From: Martin Clewlow [REDACTED]
Sent: 18 May 2017 10:51
To: Richard Temple
Cc: violainer@btinternet.com
Subject: Re: FW: Y/13/17/DOC 38 Cherry Avenue, Yapton

GROUND FLOOR LAYOUT

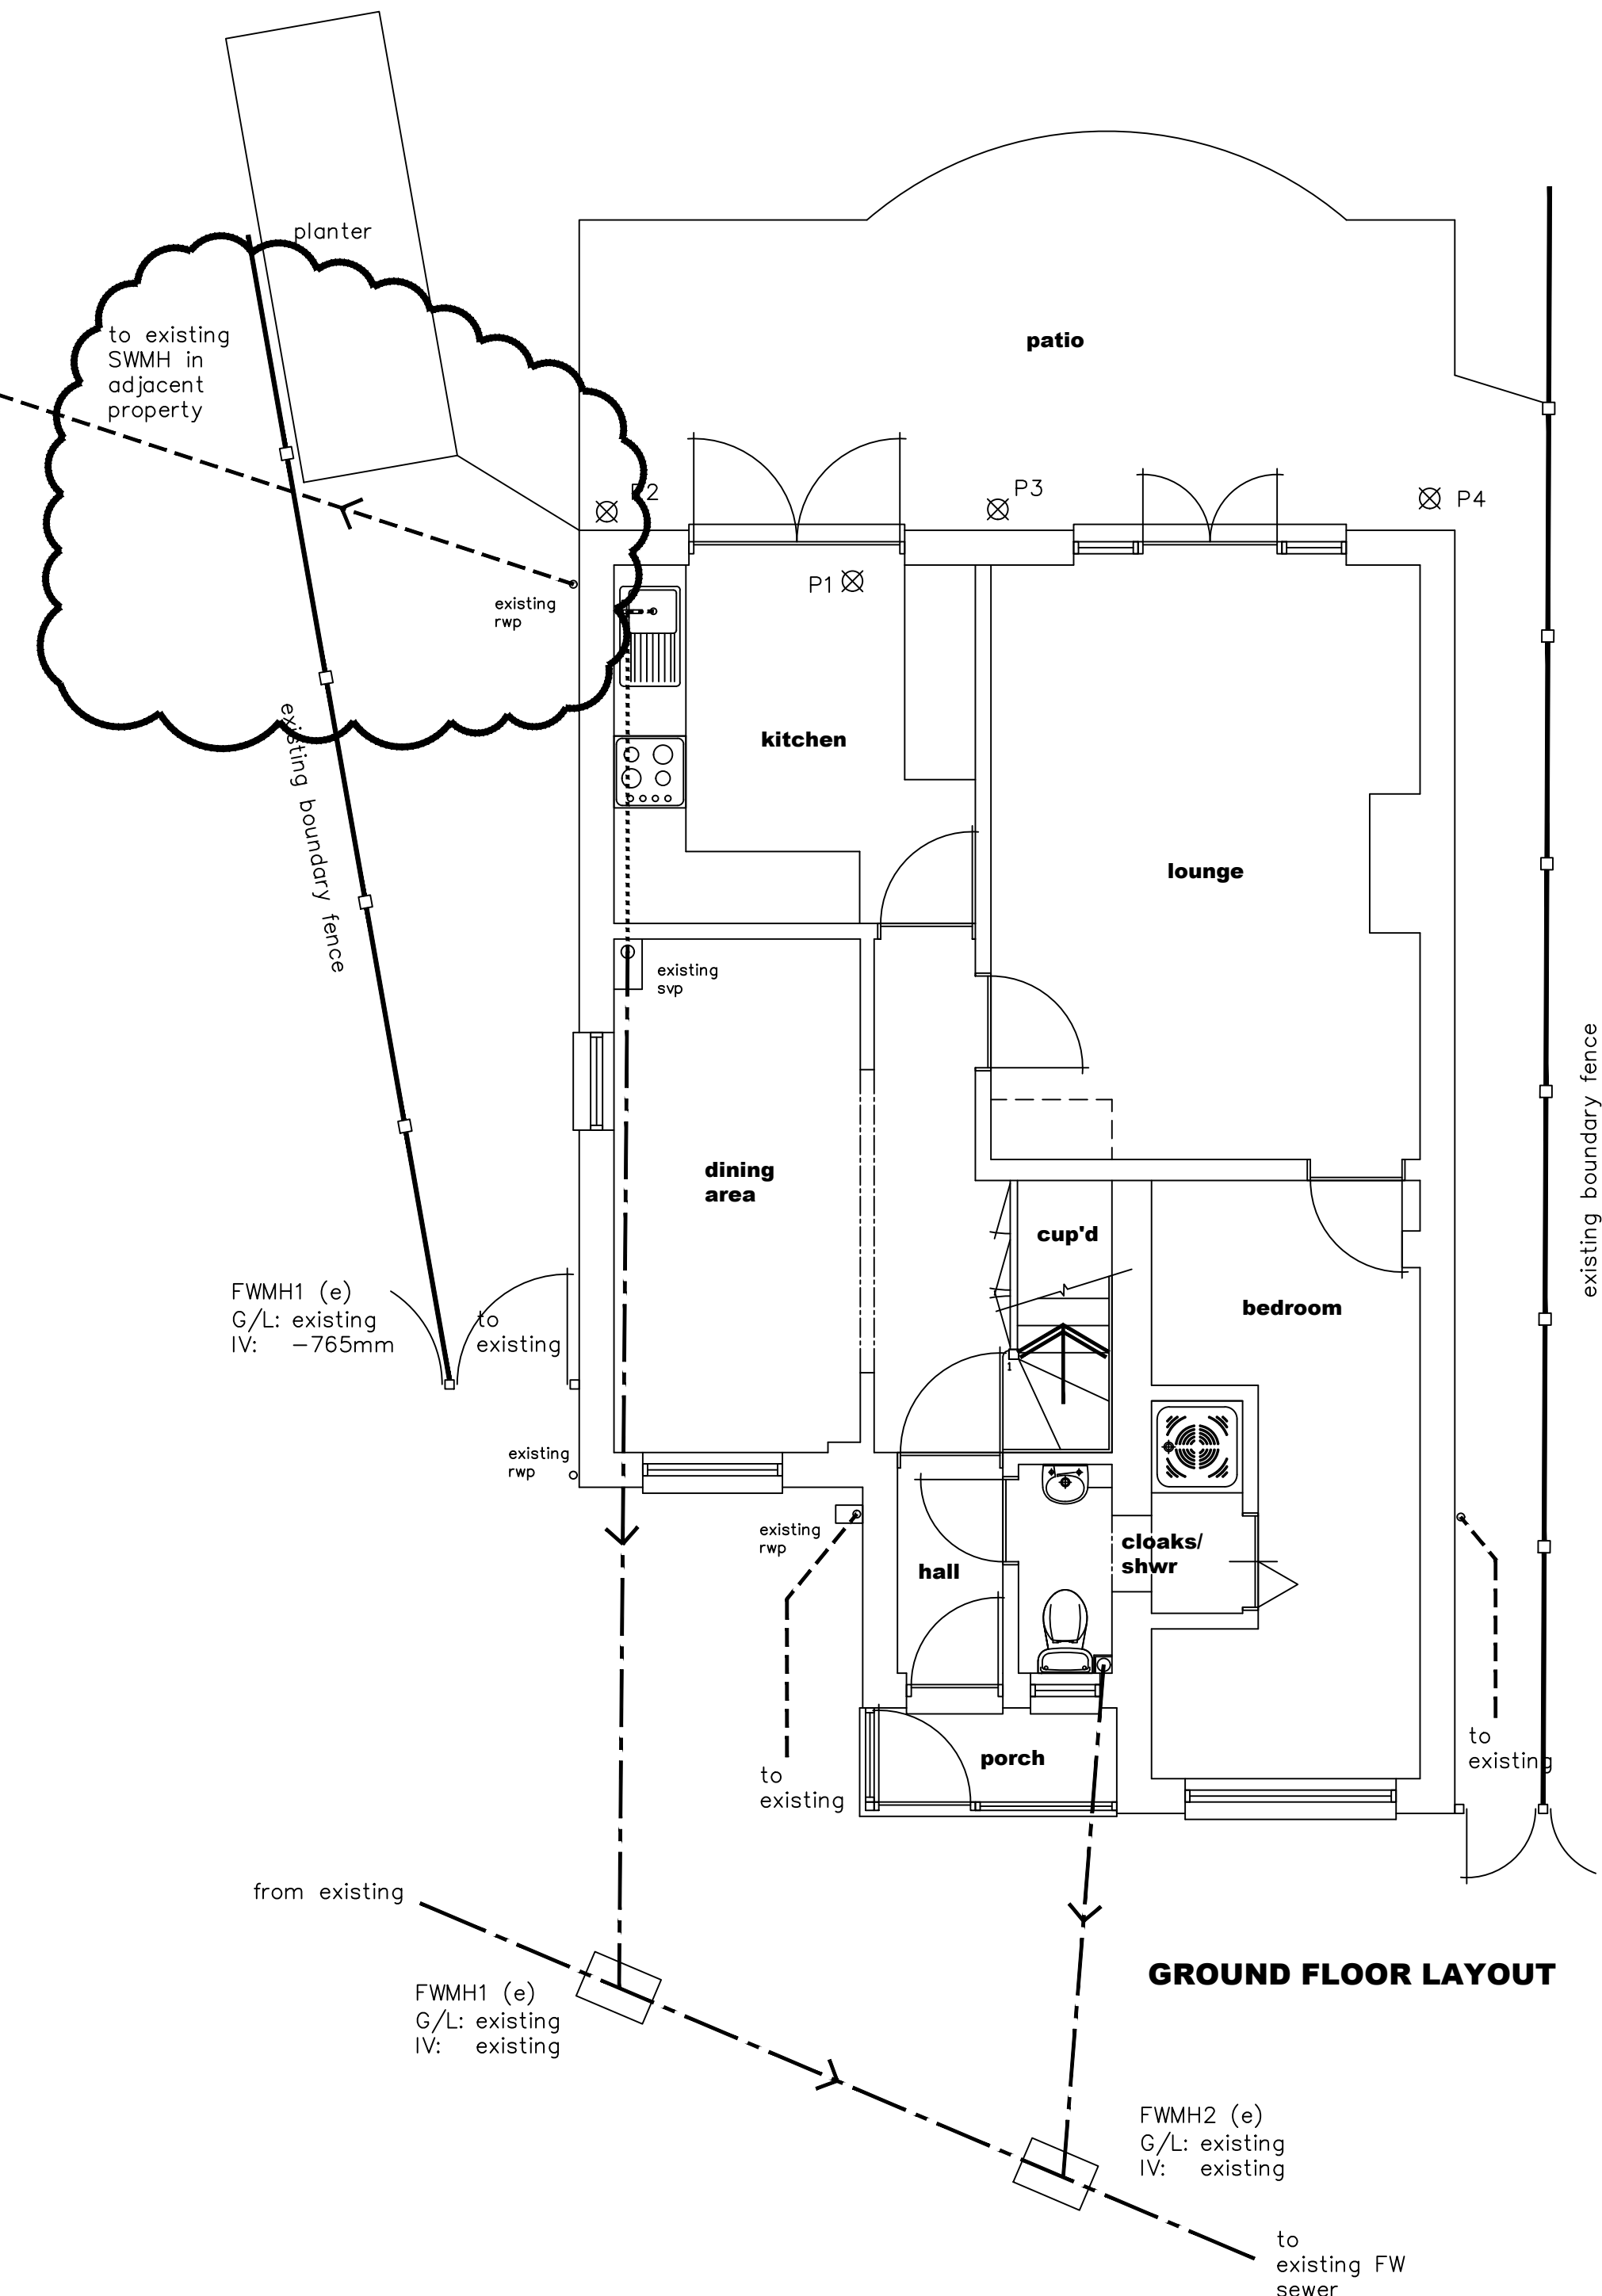
Having reviewed the CCTV survey, it is apparent that the existing pipe appears in good condition but is only 100mm diameter. On that basis, the connection from the new extension is acceptable provided that a new manhole (construction details required) is constructed where the new rainwater pipe will connect to the existing pipe.

As promised, please find attached the updated layouts which show the as existing SW system into the adjoining property as per the findings of the CCTV survey. I have also amended the proposed layouts to take on board the recommendations of your Drainage Engineer.. Hopefully this will satisfy his requirements and enable the condition remaining on this project to be approved.

GROUND FLOOR LAYOUT

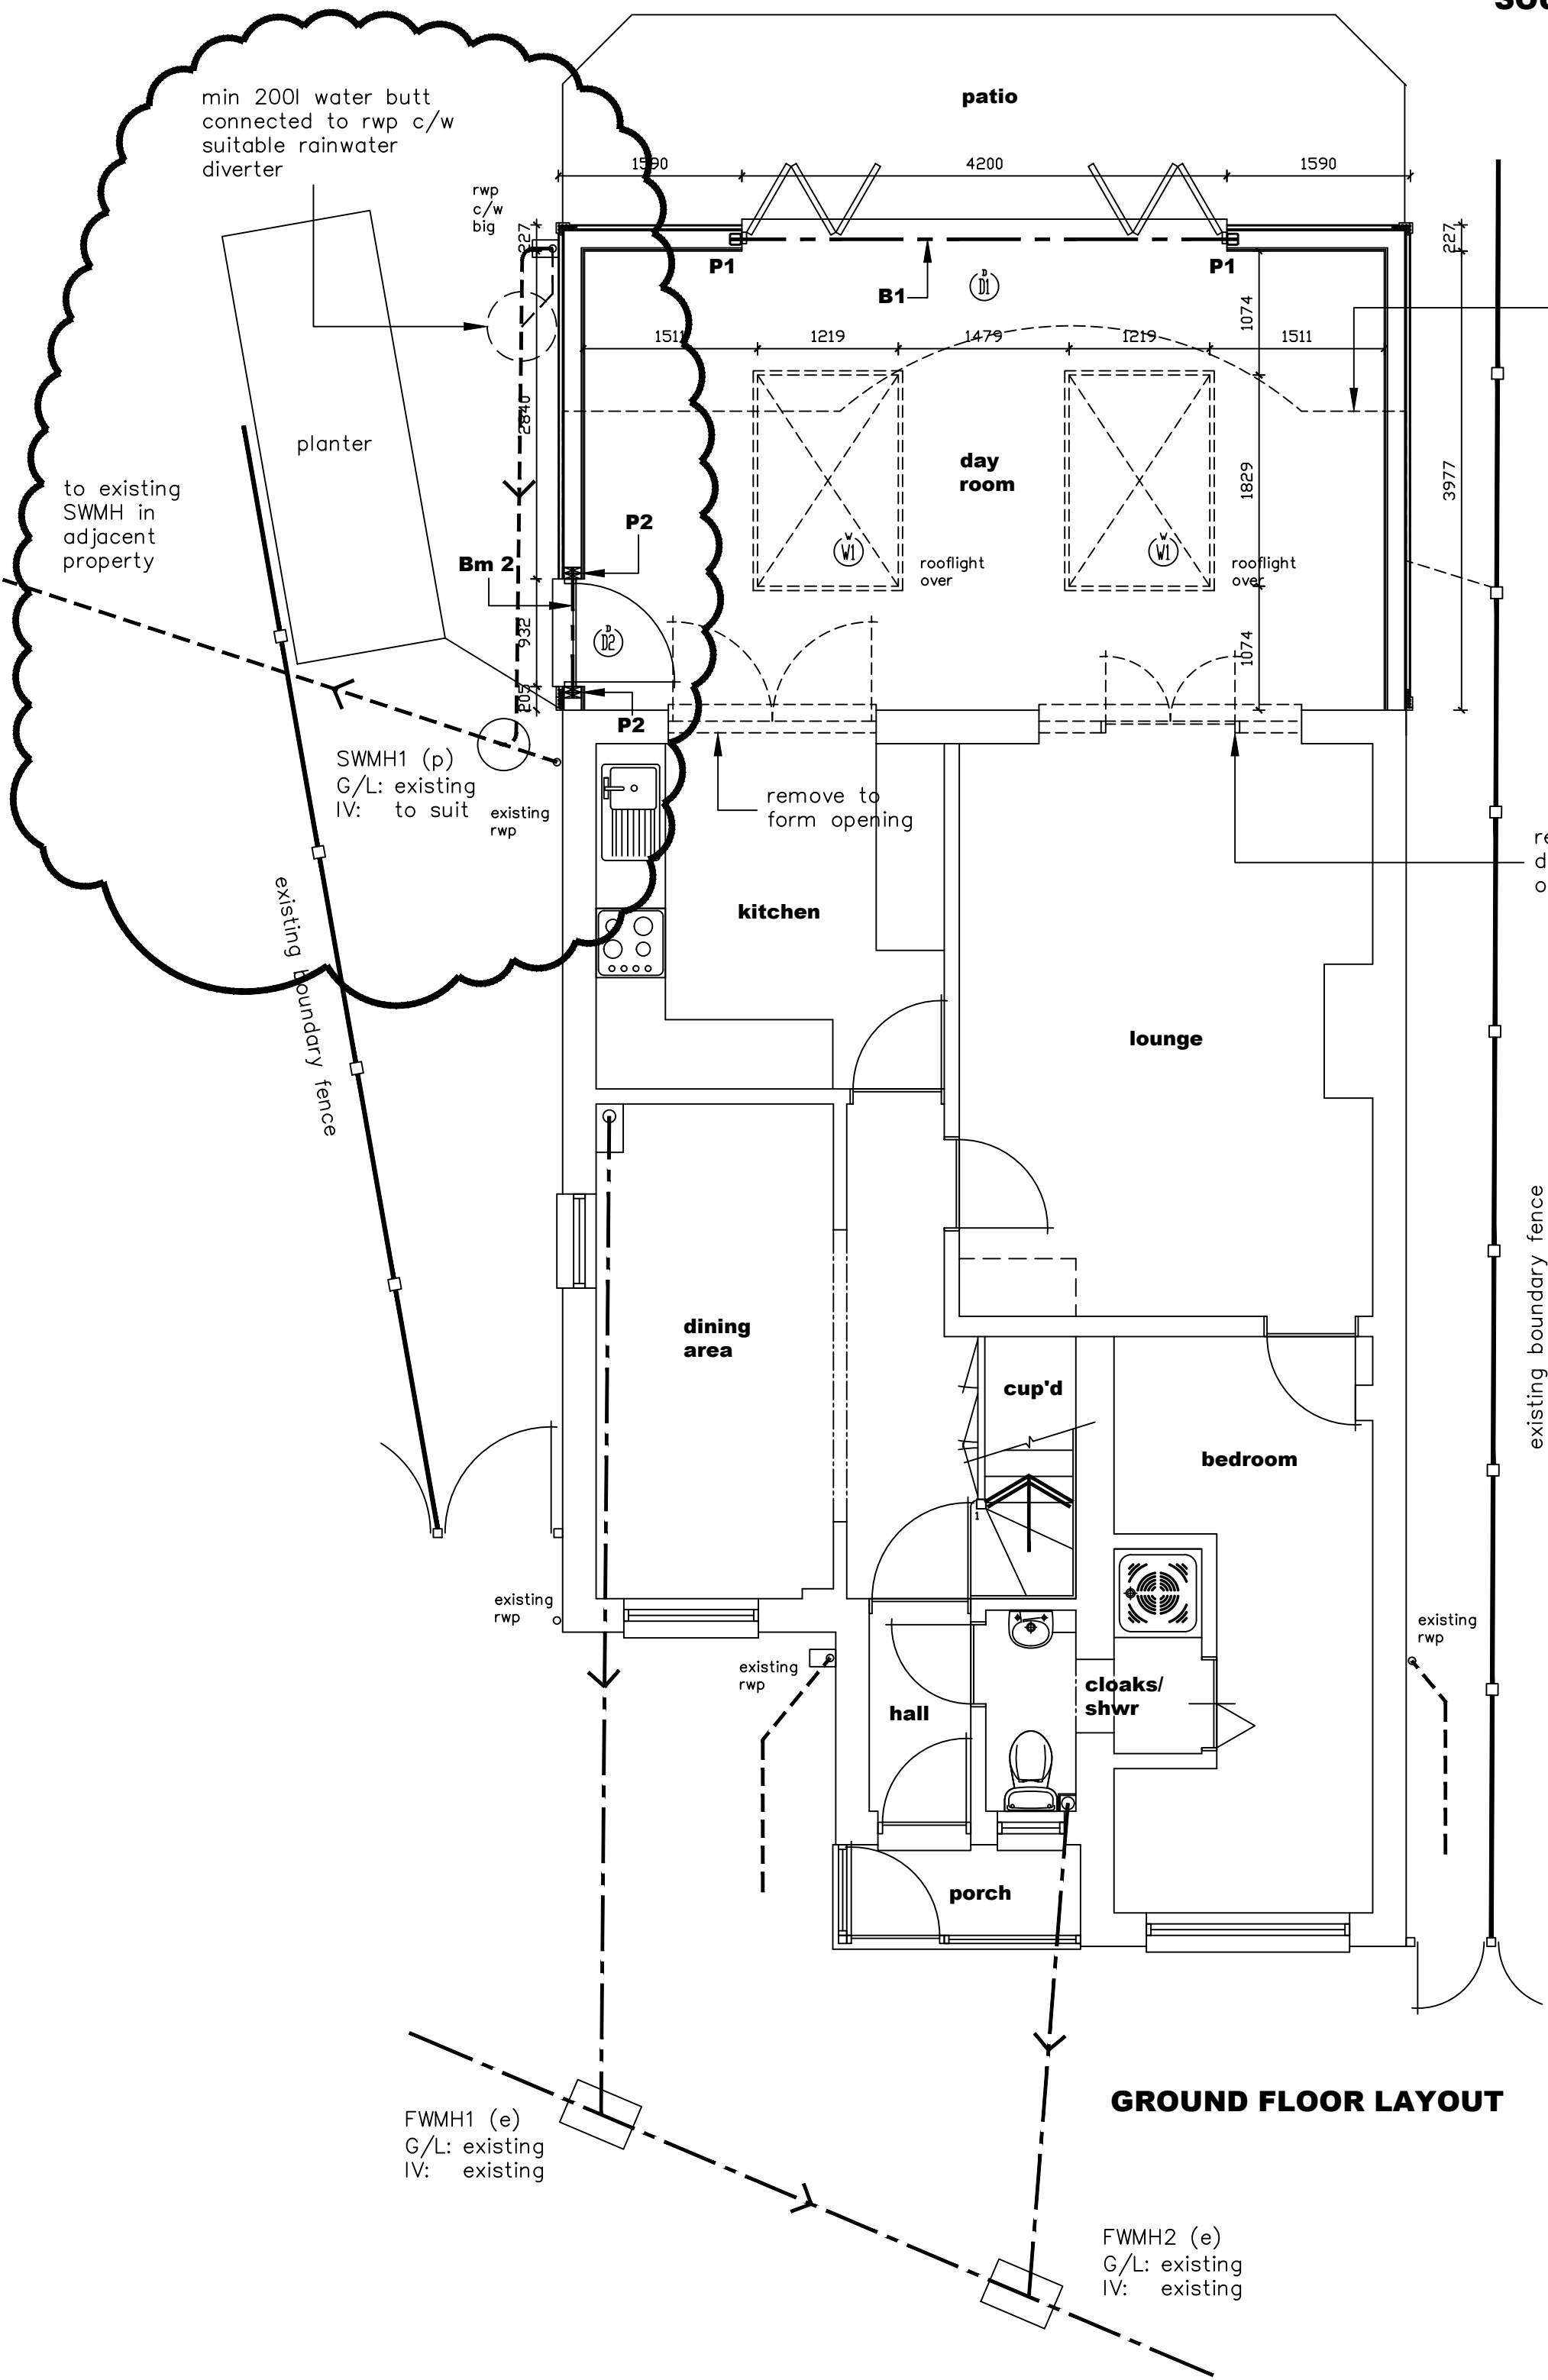
Also, a minimum 200 litre water butt is to be connected to the new rainwater downpipe via a water diverter/overflow. See enclosed picture of the diverter/overflow arrangement. The water butt will help store water at times when the water butt is empty/partially empty, and when full will overflow back into the piped system.

Please could the applicant provide a revised plan indicating these requirements, so that it can be considered further.
